Your Ref: **ACP-323824-25**

Re: Notification under the Planning and Development Act, 2000, as amended.

Colm Quigley: Application for substitute consent under Section 177E of the Planning and Development Act, 2000, as amended for the retention of 2 no. holiday chalets for short term rental, 2 no. aerated sewerage treatment systems pumped to existing tertiary distribution field, Hot tub, access roadways and all ancillary works.: Cornode, Garrykennedy, Portroe, Co. Tipperary.

Drawing:
Site & Landscaping
Layout.

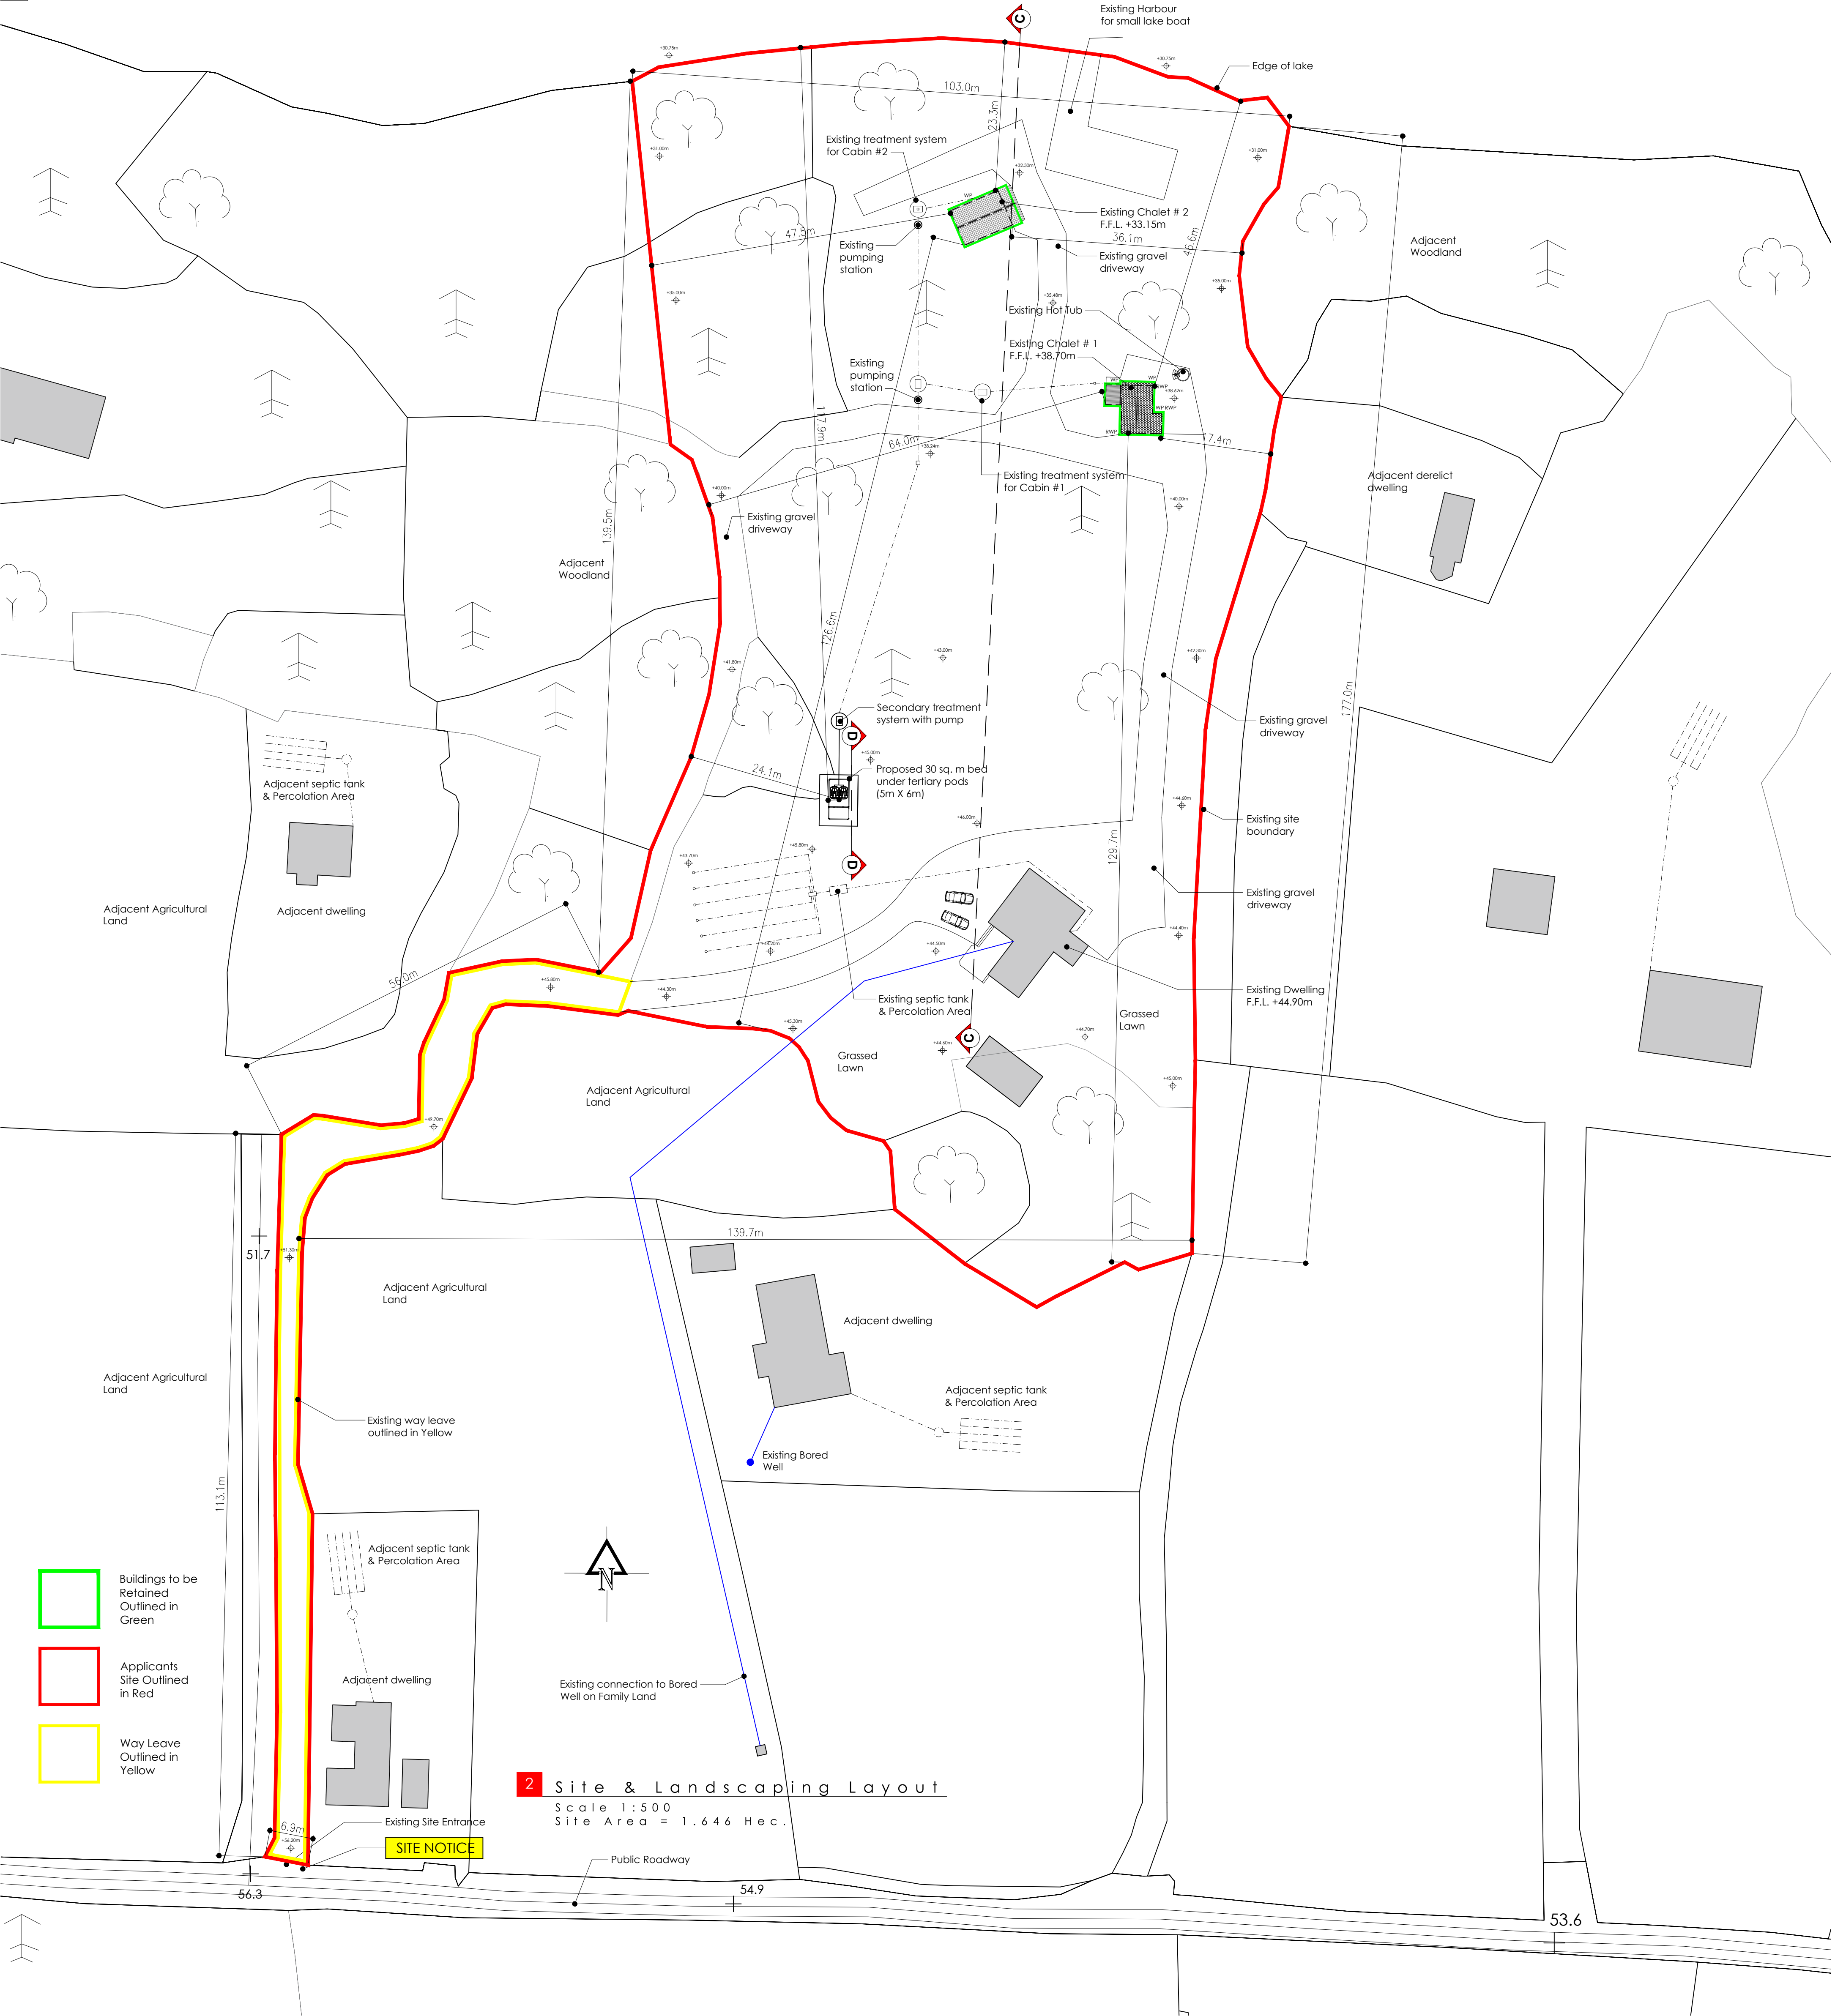
The further information has not addressed the concerns previously outlined by the Department, in relation to the impacts of riparian woodland removal associated with the development on the quality and function of the wetland habitat of Lough Derg (including the riparian areas), which has implications for both the Lough Derg SPA and the integrity of the riparian woodland corridor itself.

In particular, the loss of buffering capacity against noise and lighting disturbance, and enhanced access for aquatic recreational activities (a further potential source of disturbance) and the wider implications of this, including the cumulative impact of progressive development-related habitat fragmentation around the shores of Lough Derg have not been addressed; neither has appropriate mitigation been proposed for loss of riparian habitat area and connectivity.
